CITY OF ALBUQUERQUE
 PLANNING DEPARTMENT
 DEVELOPMENT REVIEW BOARD

Project# 1009506

- 13DRB-70758 VACATION OF PUBLIC EASEMENT
- 13DRB-70759 - TEMP DEFR SWDK CONST
- 13DRB-70760 MAJOR - PRELIMINARY PLAT
- 13DRB-70761 SITE DEVELOPMENT PLAN FOR SUBDIVISION
- 13DRB-70762 VACATION OF PUBLIC RIGHT-OF-WAY

BOHANNAN HUSTON INC agents for PULTE HOMES OF NEW MEXICO request the referenced/ above actions for Lots 14-19, **VOLCANO CLIFFS UNIT 6 (tbka MONTECITO WEST UNIT 2)** zoned SU-2 VOLCANO CLIFFS RURAL RESIDENTIAL (VCRR), located on ALBERICOQUE PL NW between VISTA VIEJA NW and SCENIC RD NW containing approximately 16.54 acres. (D-9)

ACS Monument "S\_21\_22\_28\_27\_11N\_2E"  
 NAD 1983 CENTRAL ZONE  
 X=1497658.102  
 Y=1513840.436  
 Z=5330.151 (NAVD 1988)  
 G-G=0.999671770  
 Mapping Angle=-0°16'30.19"

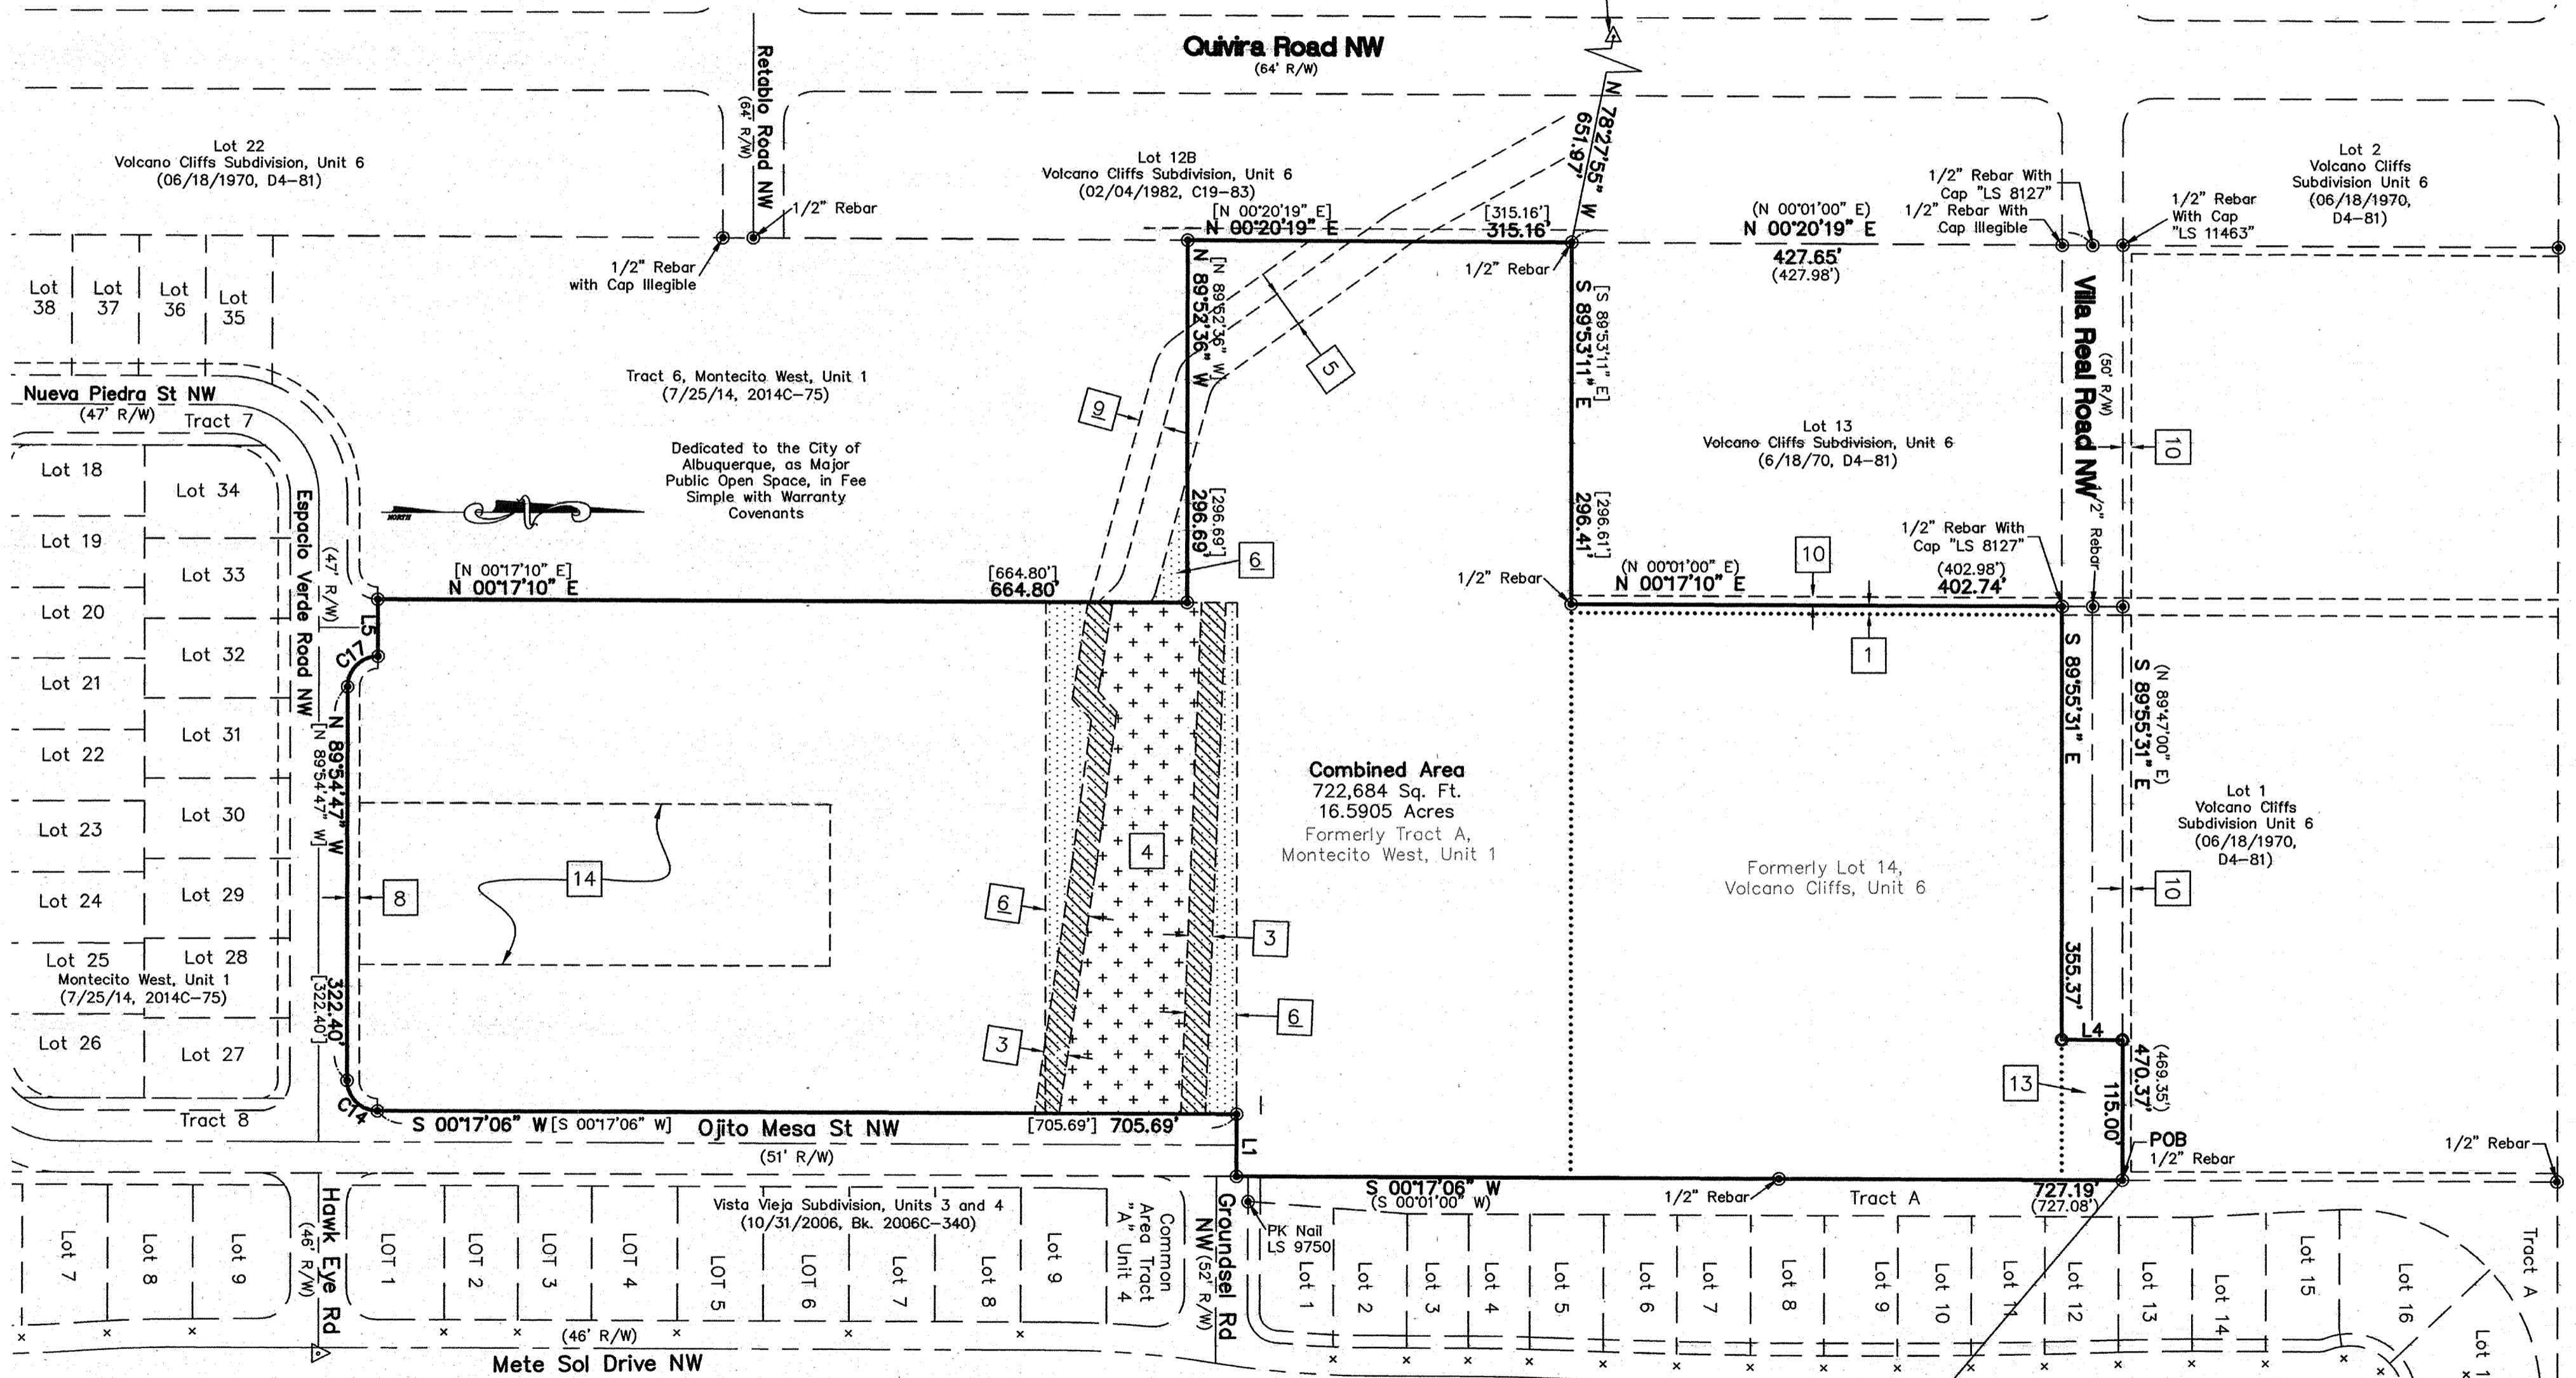
- a. More information is needed regarding the 2 HOA tracts and the 2 Private Common Area tracts.
- b. Parks & Recreation's Open Space Division requests that the Parceled Commons Areas Tracts 1 and 2 be dedicated to the City to be managed as public Open Space by the Open Space Division. Please change General Notes #6 to reflect this change.

- c. The Public Open Space will need to be fenced with open space fencing prior to construction of adjacent infrastructure and residential lots to prevent damage to existing vegetation. Fencing to be added to Infrastructure List.

- d. Please change all references to Private Commons Areas (PCA) as the name has been changed to Parceled Common Areas (PCA) within Private Commons Development (PCD). Per the Ordinance, Parceled Common Areas can be Public or Privately owned and maintained. In this request, the Parceled Commons Areas shall be Public Parceled Commons Areas.

- e. Provide note in General Notes stating the responsibility of the HOA to maintain the 2 HOA tracts.
- f. Line weights in the Legend are difficult to differentiate on the Plat.
